From: Andrew Wood
Sent: 25 May 2017 17:14
To: Planning.Responses
Subject: FW: FG/198/17/PL

Subject: FG/198/17/PL

FEL 5.800 AOD

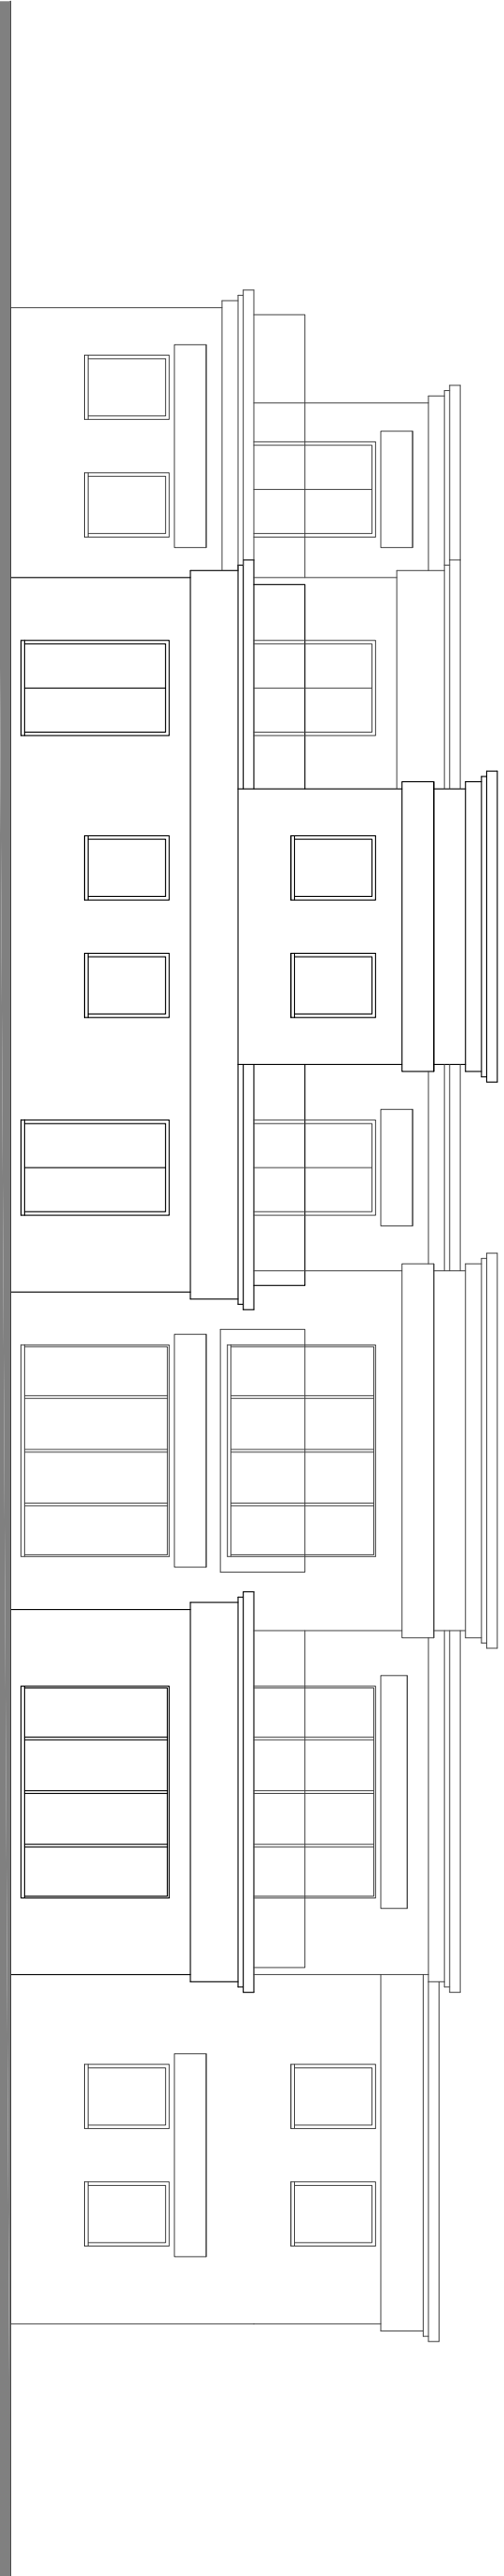
It has requested that the 'finished floor levels are set no lower than 5.8m above Ordnance Datum (AOD).'

An objection has been received requesting that it is confirmed that the building will be of the height shown it is alleging that once the permission has been granted. I would consider that this issue would be likely to be raised at committee. Can you confirm that on the plans as submitted the 'finished floor levels are set no lower than 5.8m above Ordnance Datum (AOD).'

With reference to your email below and our subsequent conversation this afternoon, I confirm that the ground floor finished floor level is to be set no lower than 5.8m above Ordnance Datum.
